STATE OF NORTH CAROLINA
DEPARTMENT OF TRANSPORTATION

April 2, 2019

Subject: Revised Application for Section 404 Individual Permit and Section 401 Water Quality Certification for the proposed Havelock Bypass in Craven County. TIP No. R-1015. WBS 34360.1.2

SEE PROJECT COMMITMENTS
FOR SPECIAL CLEARING FOR
-L- STA. 338+00 TO 393+00

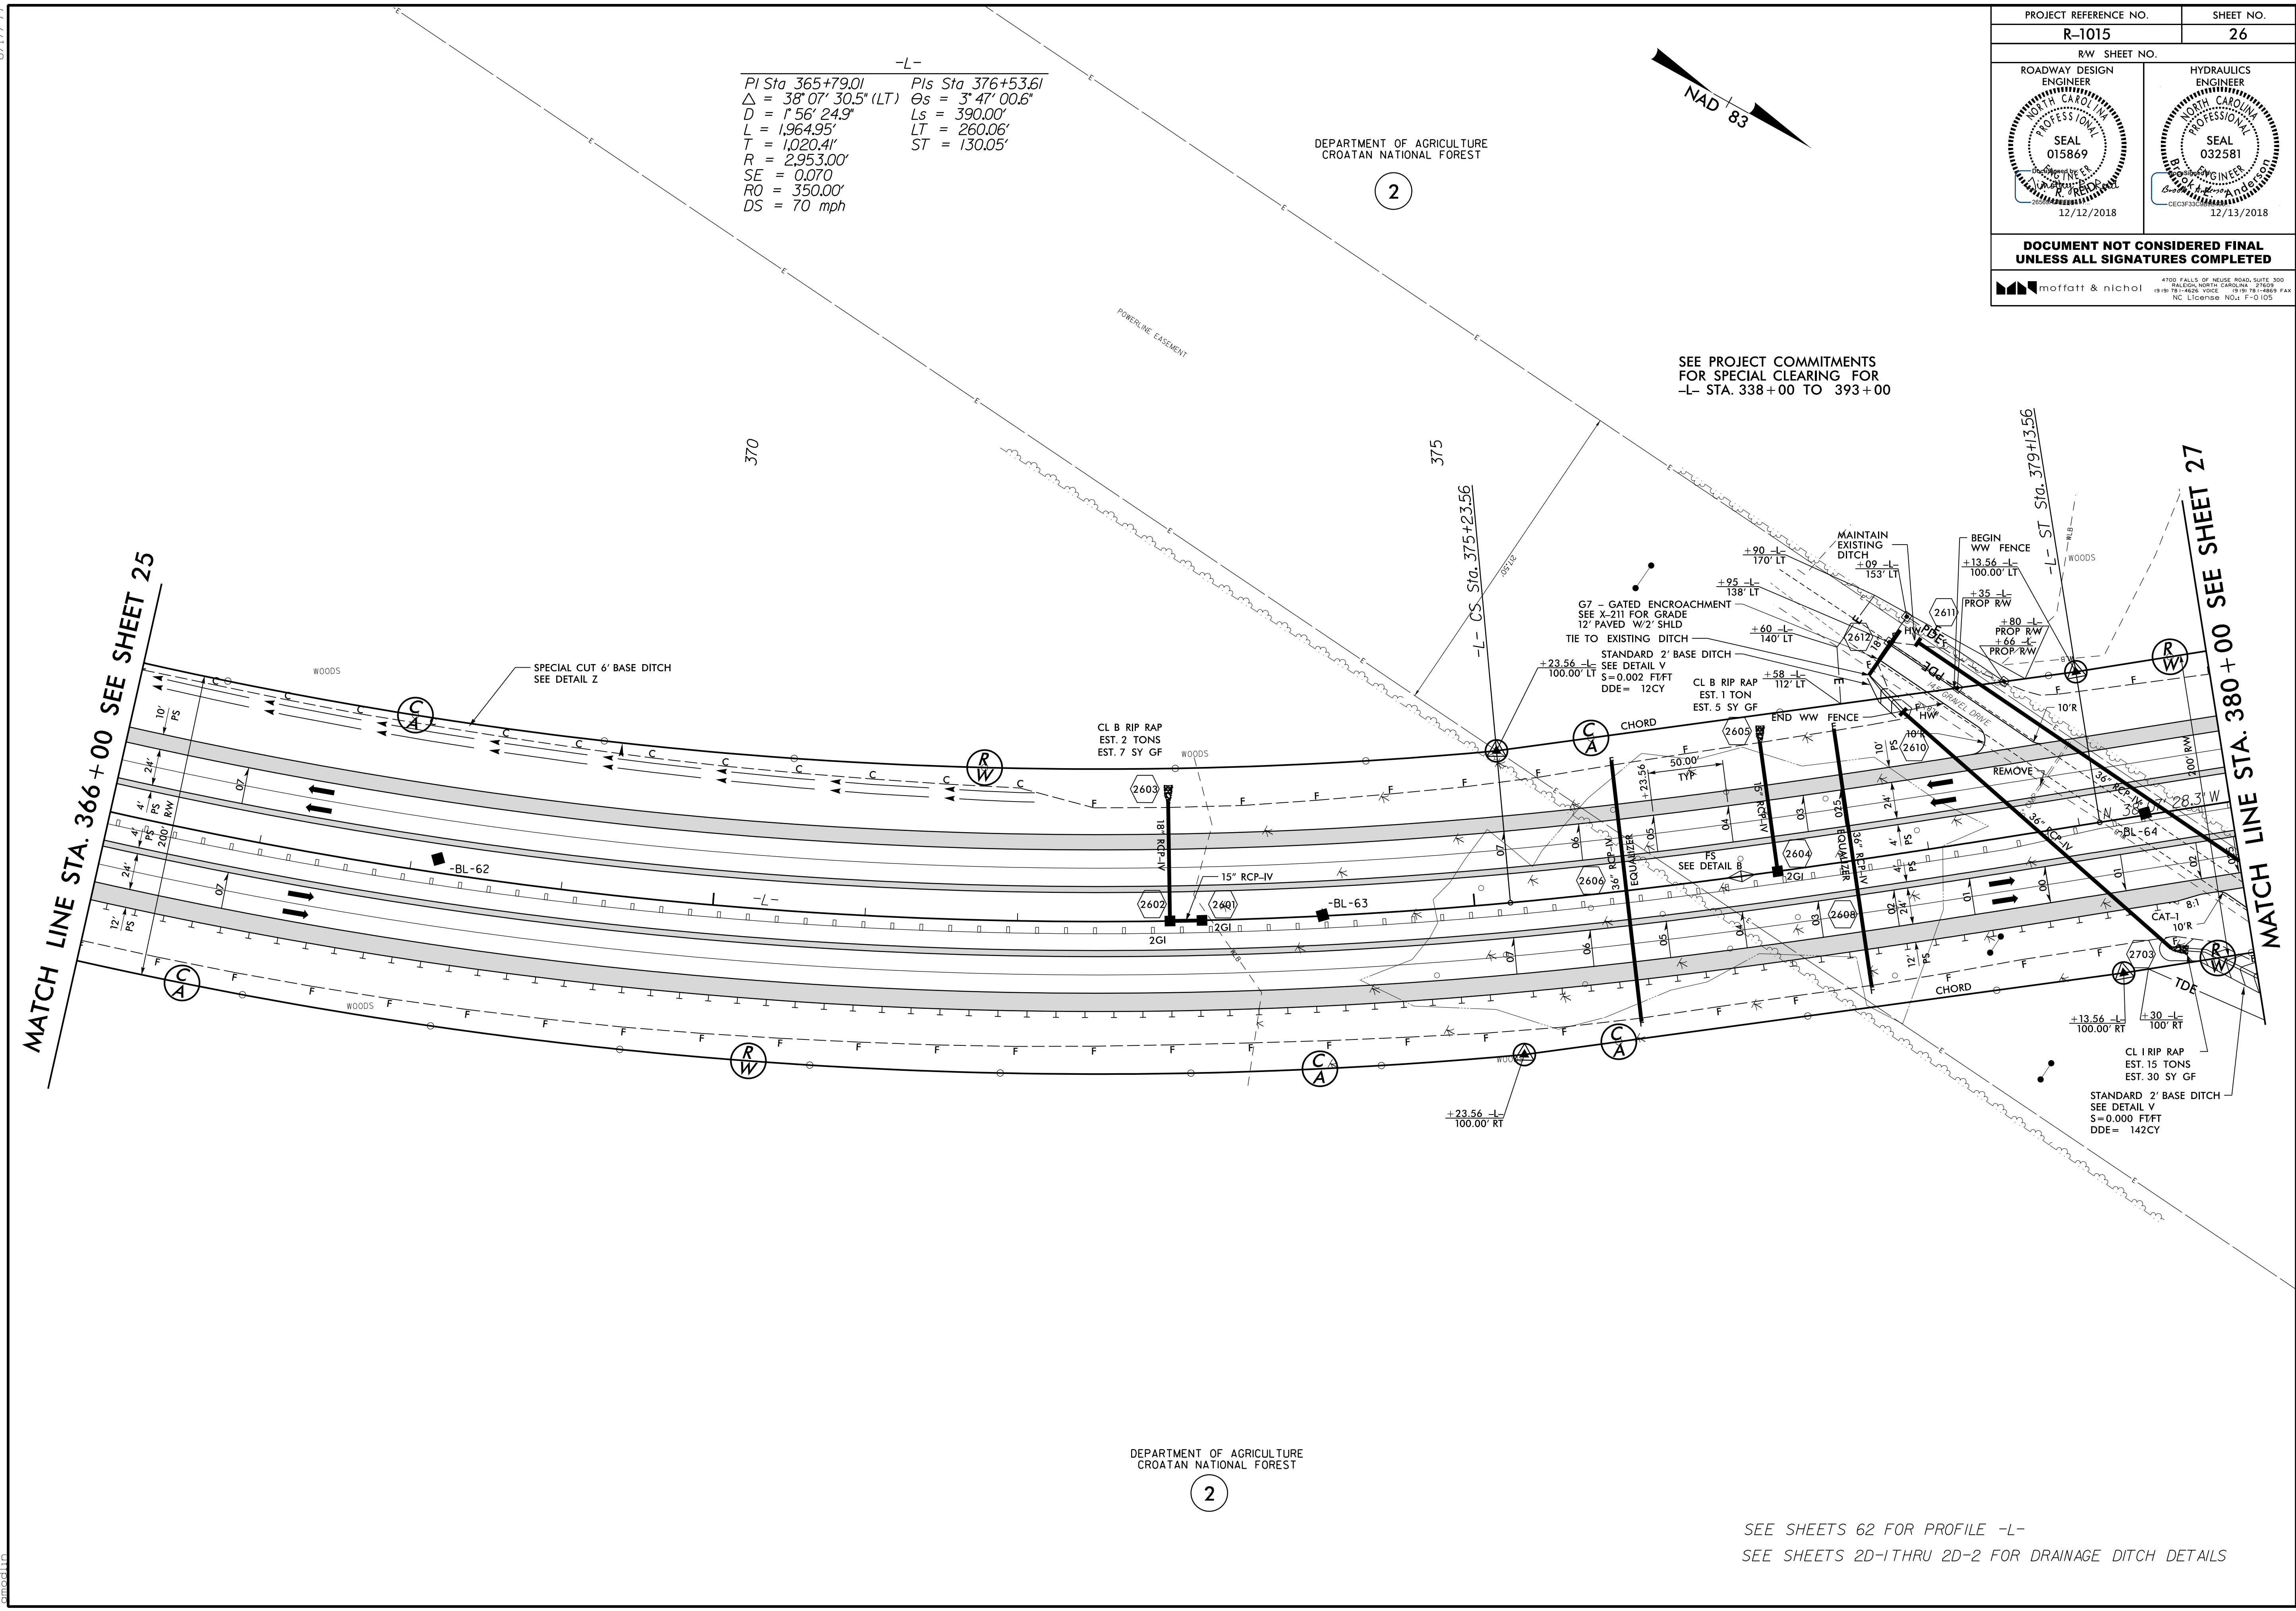
Enclosed you will find revised permit drawings for the area between stations 338+00 to 393+00. This affects permit sites 26, 27, 28A, 28B, 29, 30, and 31. The mechanized clearing shown at those sites has been changed to hand clearing. This coincides with the clearing restrictions already indicated in the erosion control plans. Revised summary sheets are also enclosed, which show the shift of 0.6 acre of wetlands clearing impacts at the affected sites from the mechanized land clearing column to the hand clearing column. As a result, the Department will reduce the proposed compensatory mitigation to correspond with this reduction in permanent impacts. A copy of the latest NC Division of Mitigation Services acceptance letter forthcoming.
